Re: BP#2016-01901 49 Hancock Street

Laurie Leader
Plan Review/Code Enforcement
City of Portland, Maine

**COV**

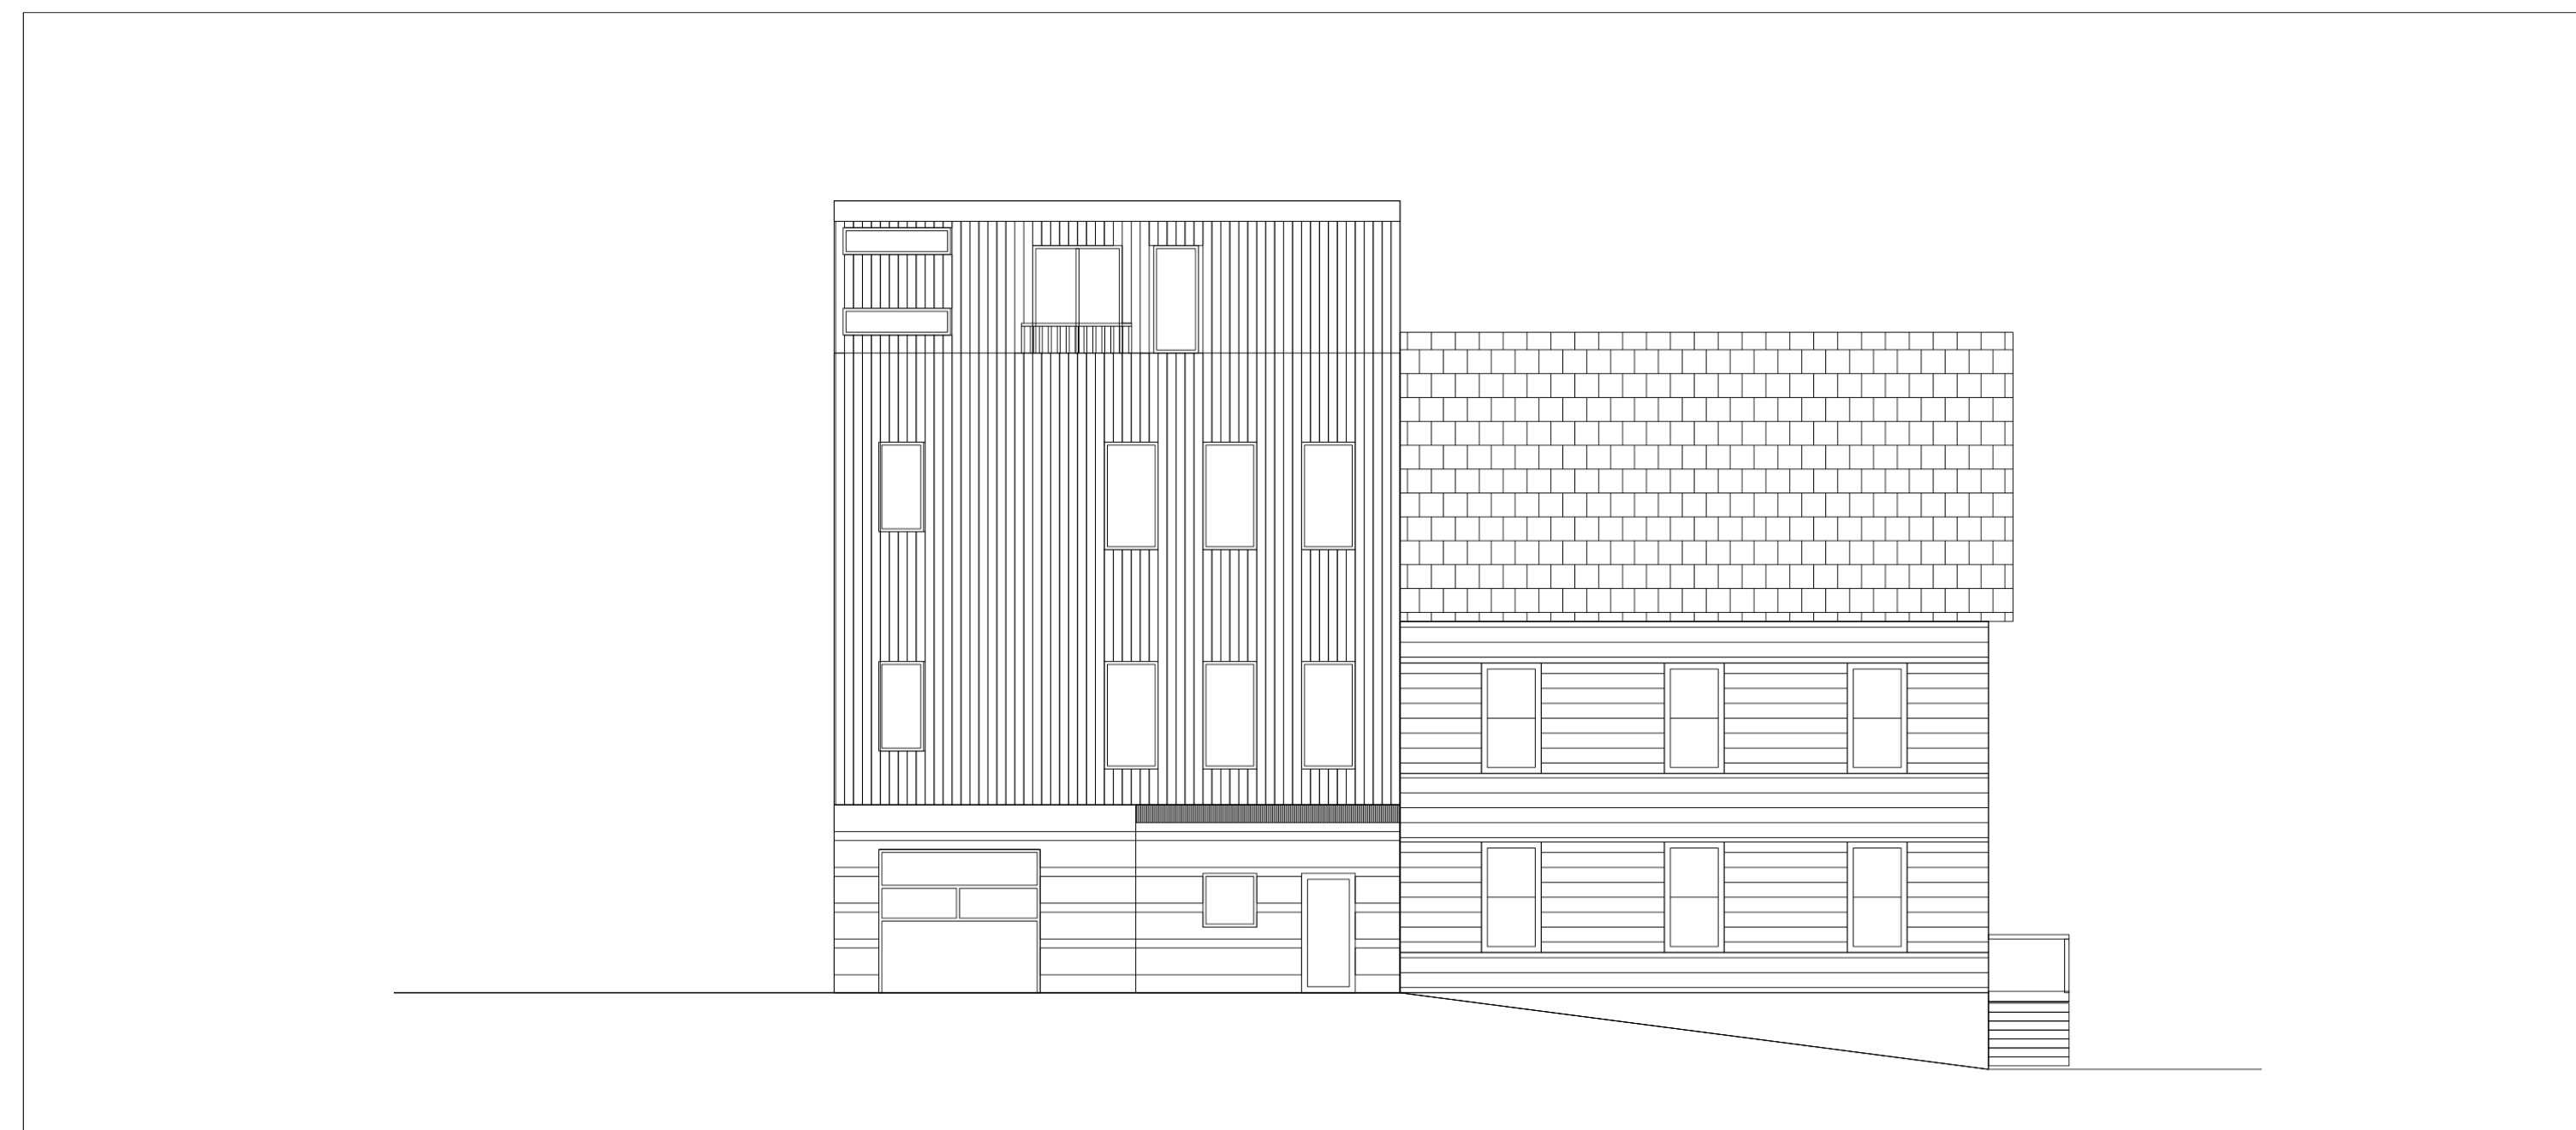
- I do not see the cover sheet attached. Can you please forward revisions for Cover 1.0.
- I do not see the revised life safety plan LS 1.1. Please revise travel distance and resubmit.
- Given line item 3 on email dated December 6, 2016, can you eliminate calculations on elevations and clarify that all openings on the south elevation will be protected.
- Provide special inspections for the intumescent fire-rated coatings.

1. I have attached Cover sheet with this email. Please review.
2. I have attached LS 1.1 with this email. Please review. As discussed previously, it is little over 50' and would like to use IBC 2012.

FOUNDATION PLAN  
1/8" = 1'-0"

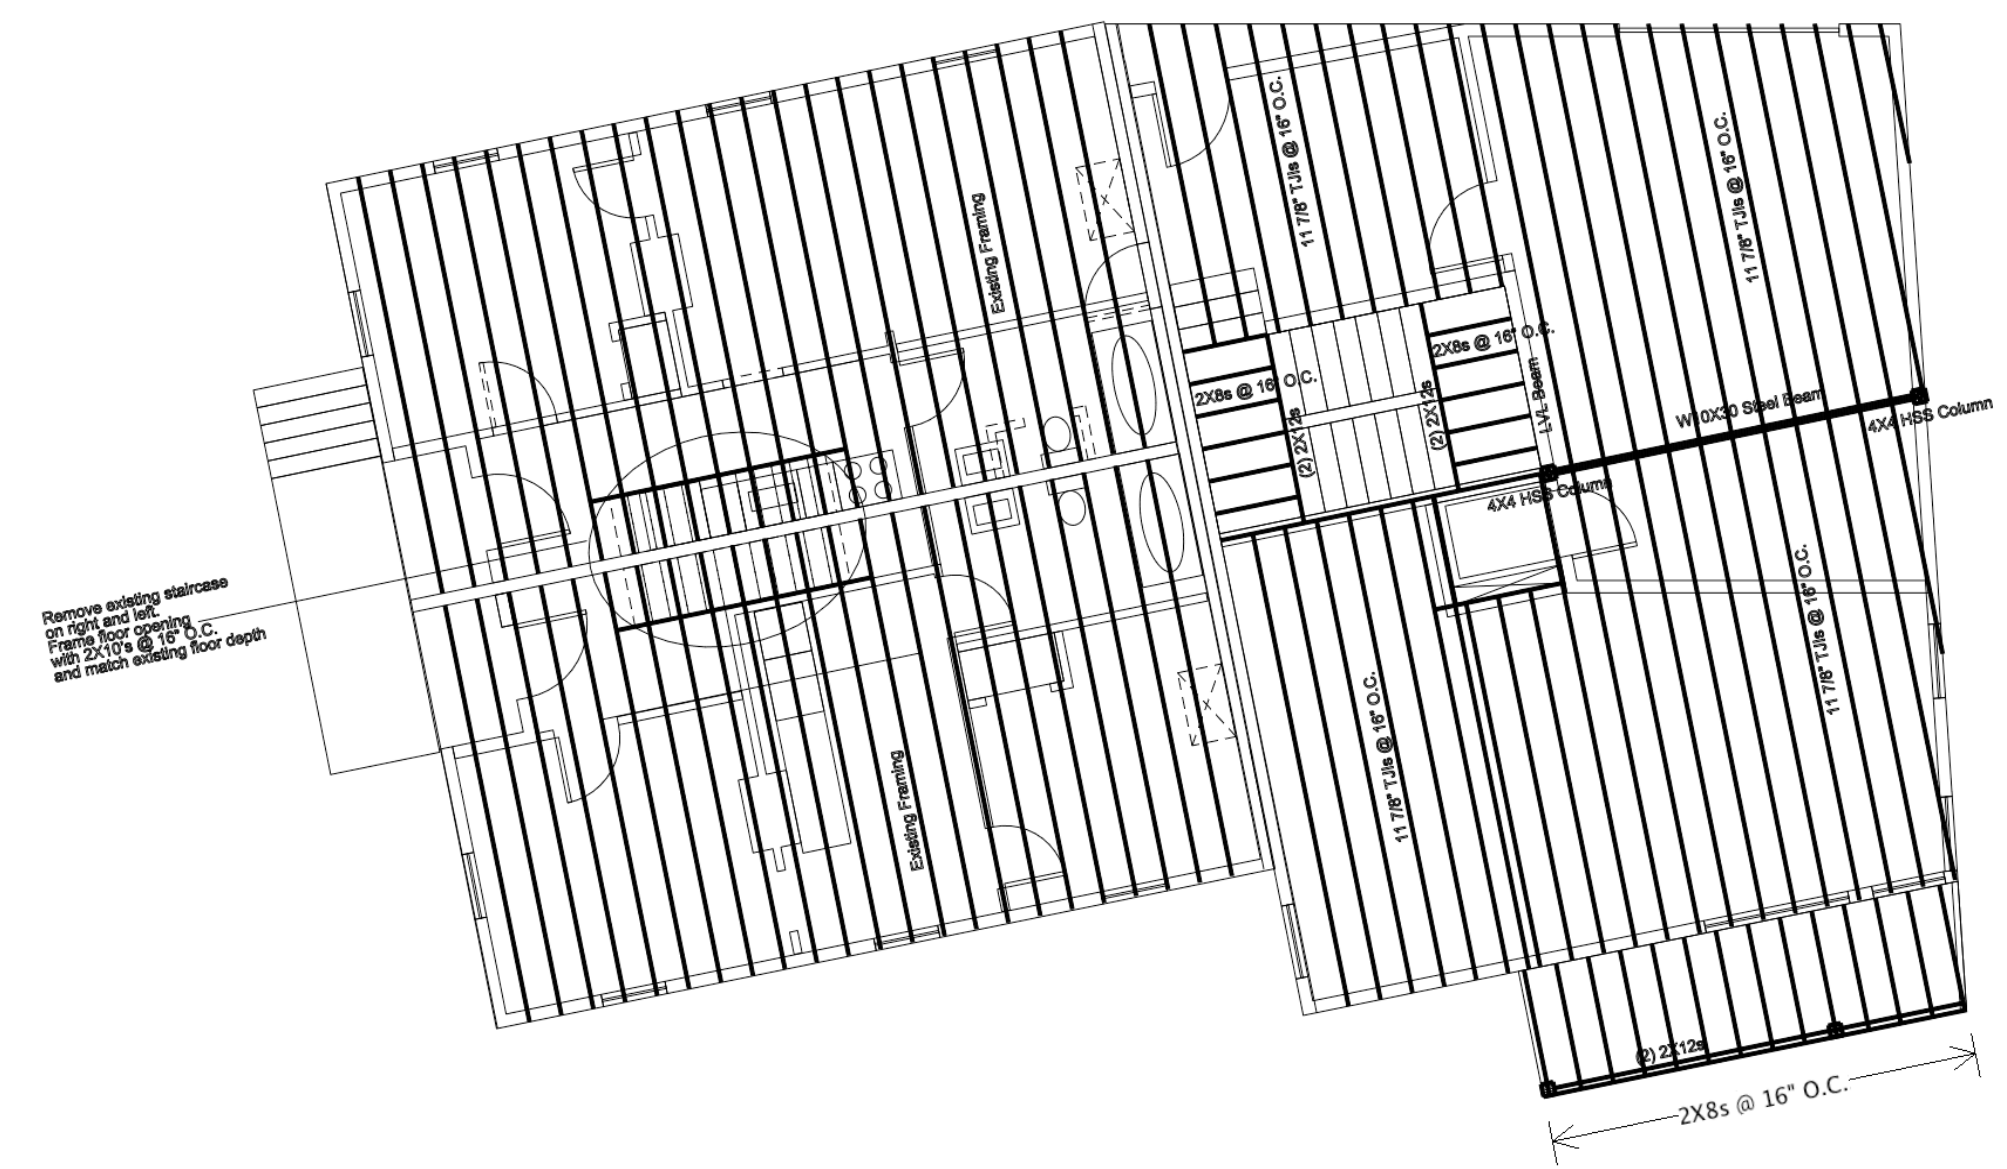
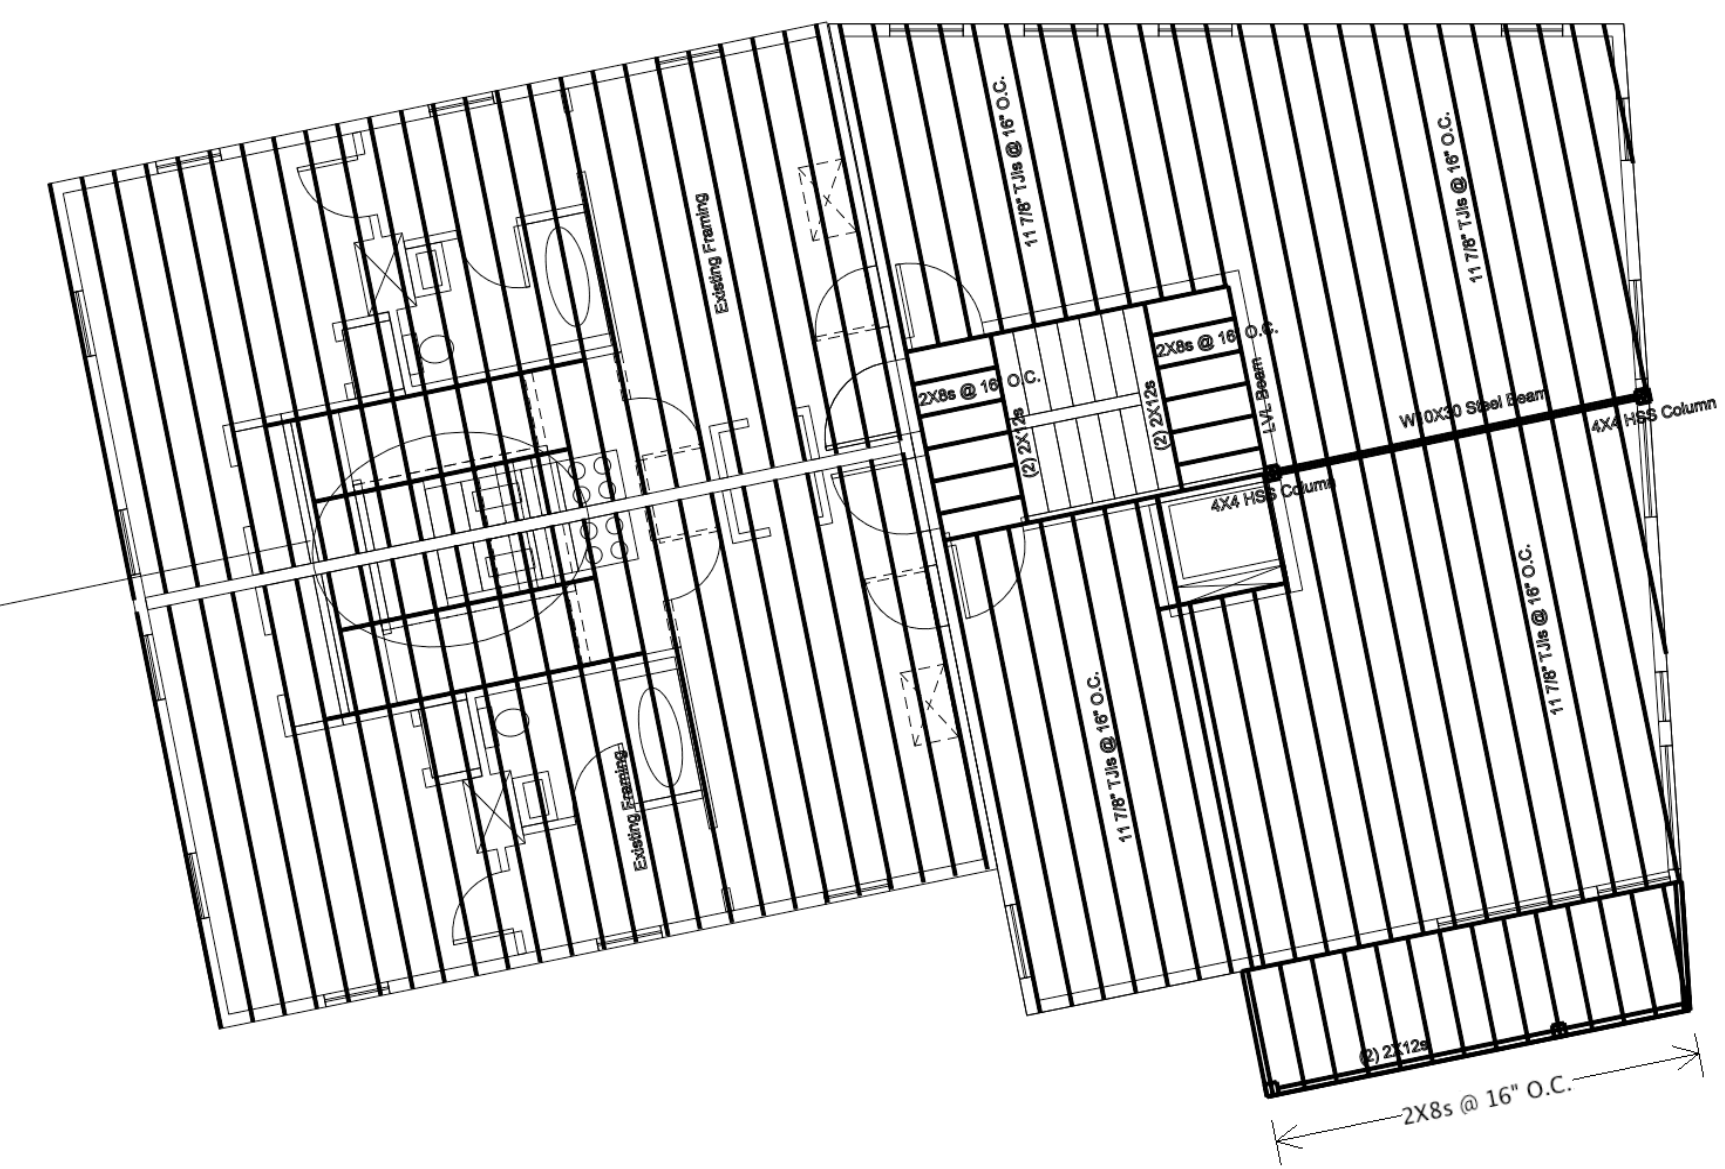
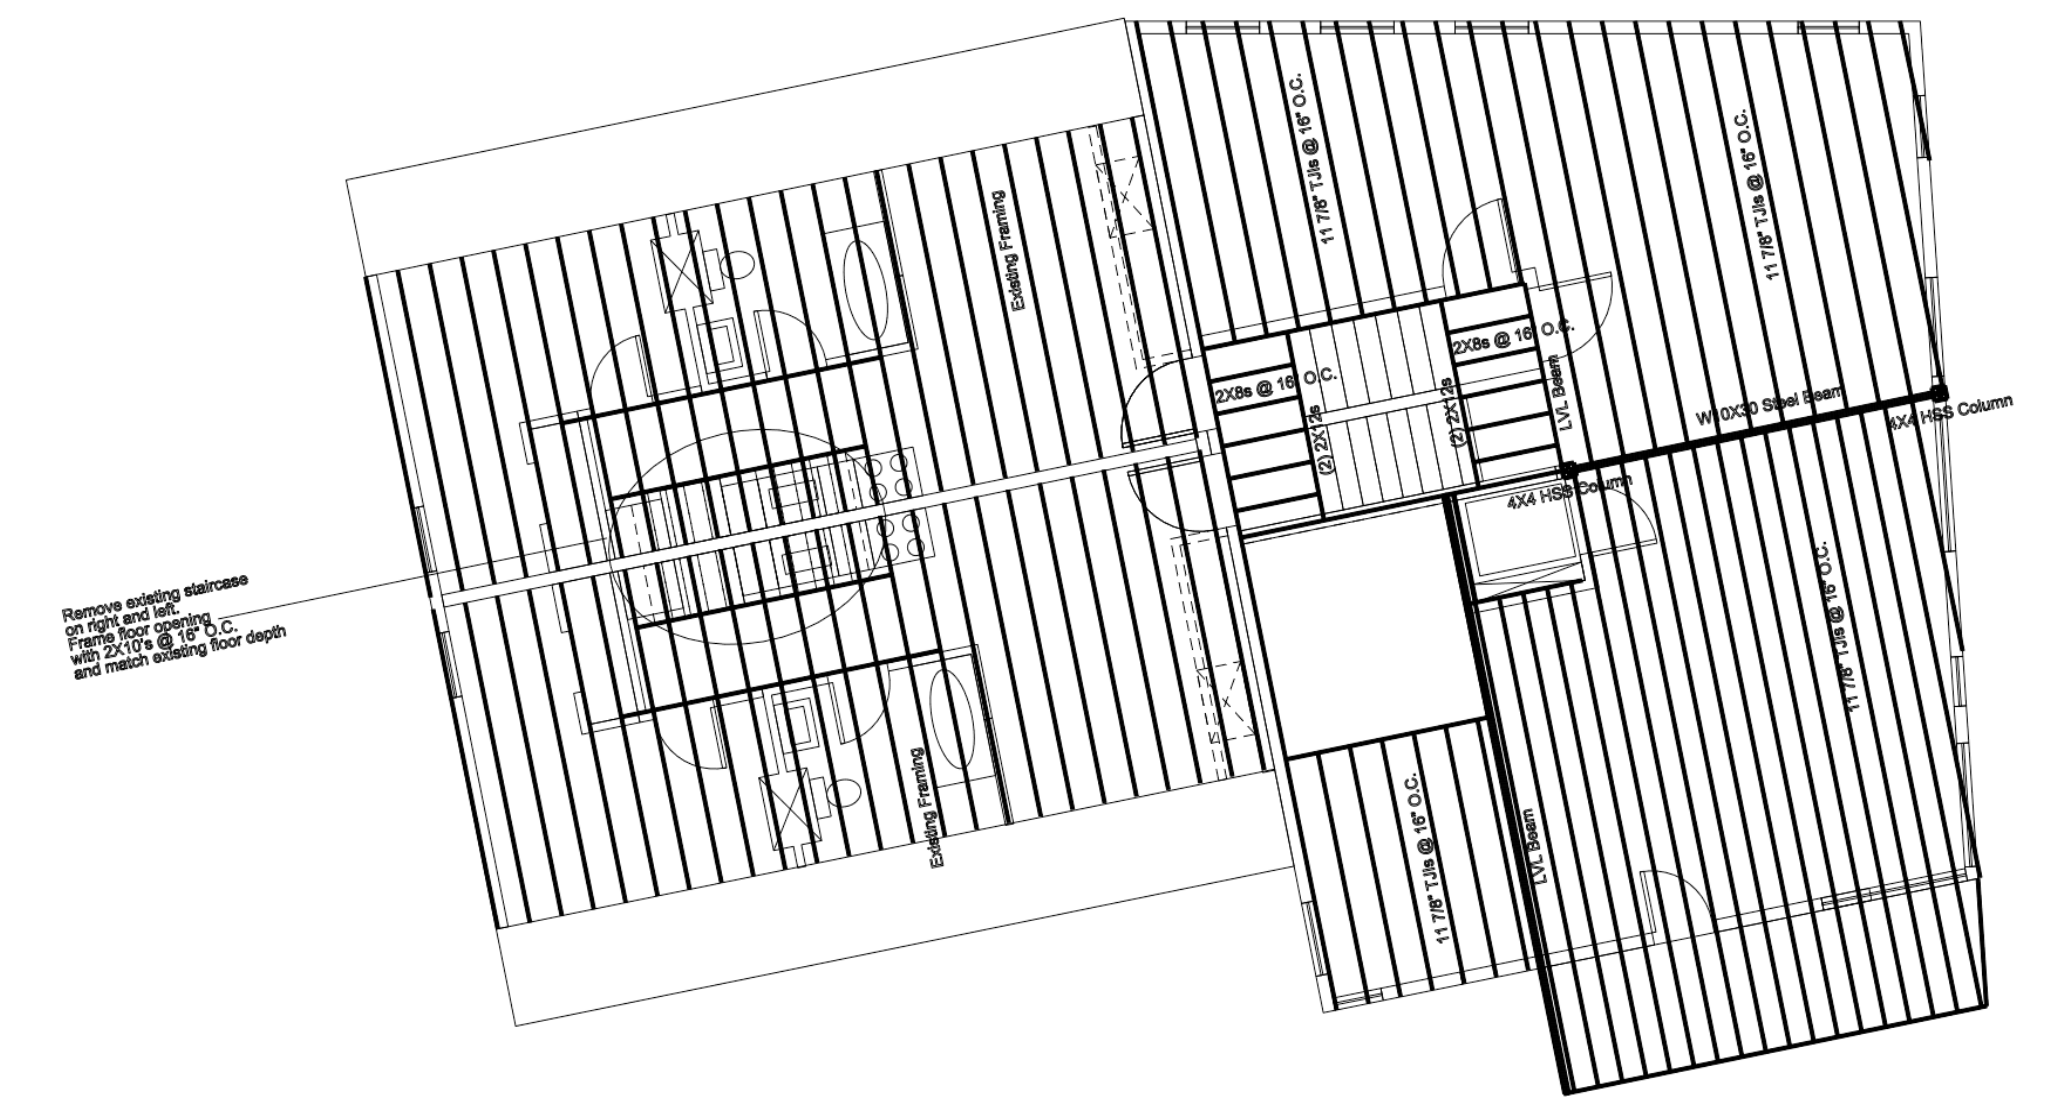
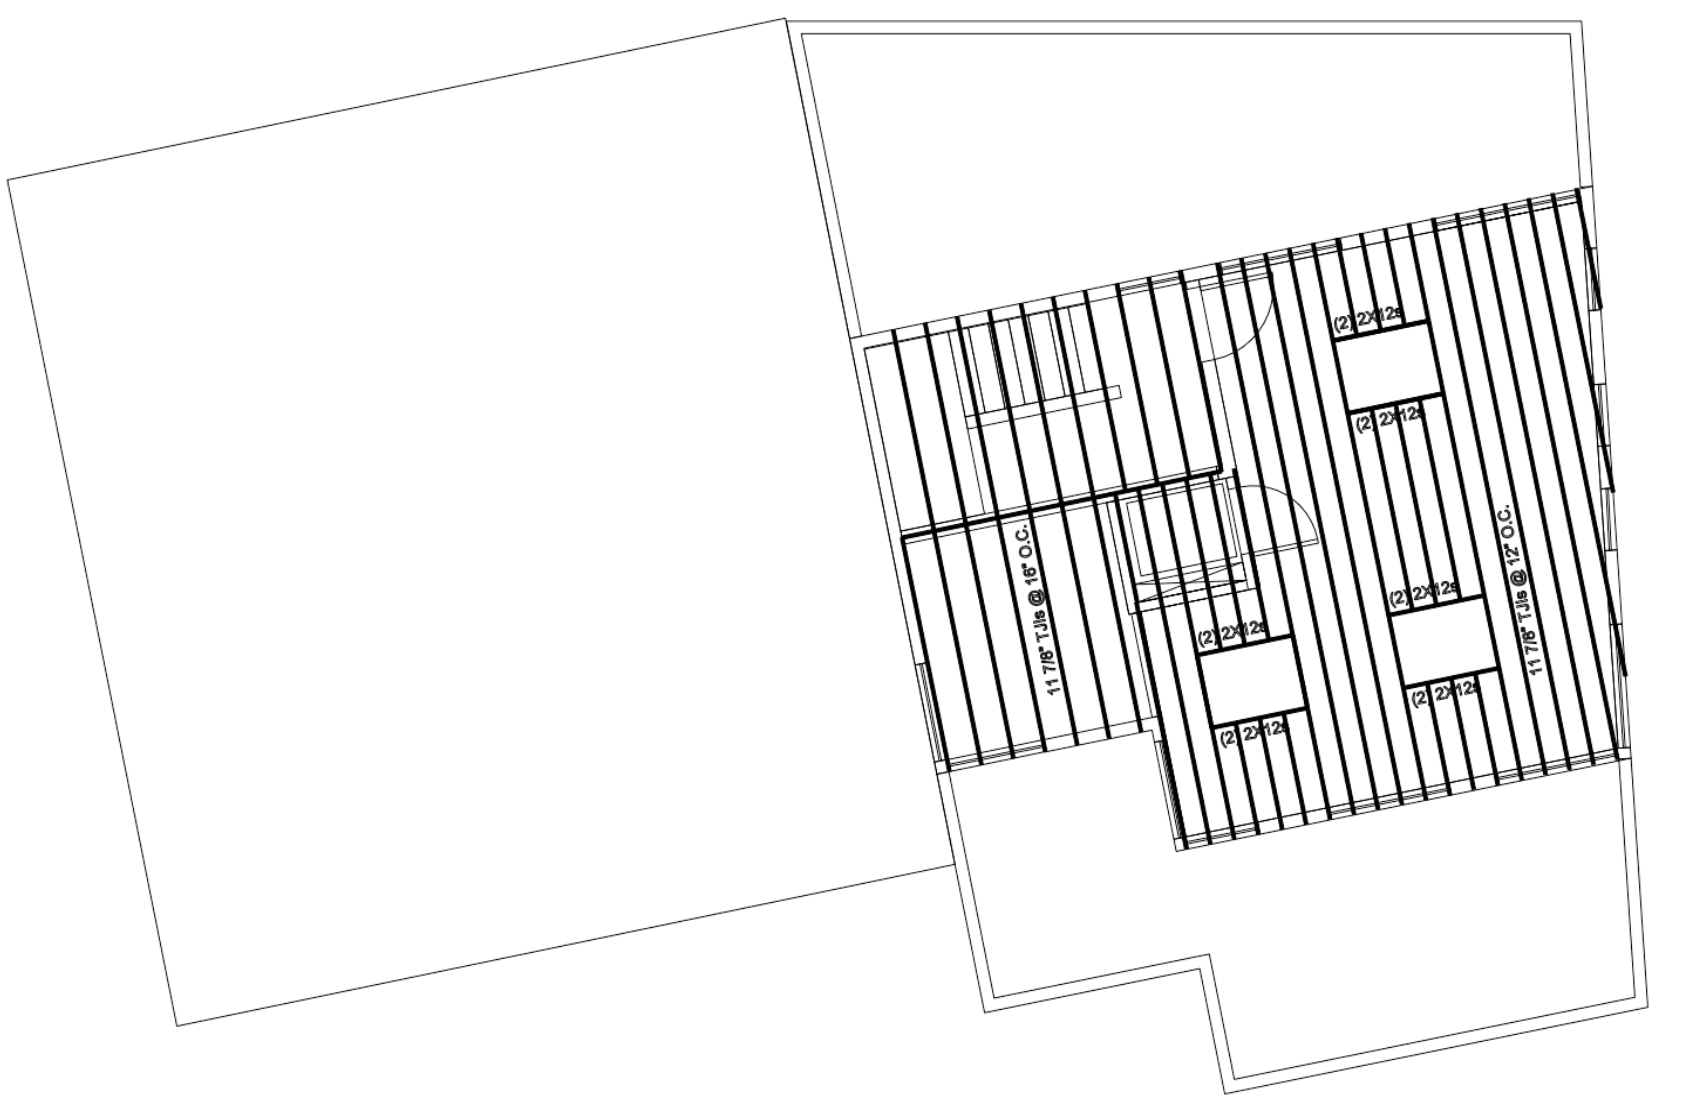
8. S1.1 Foundation added for deck posts. Deck posts to be steel posts.
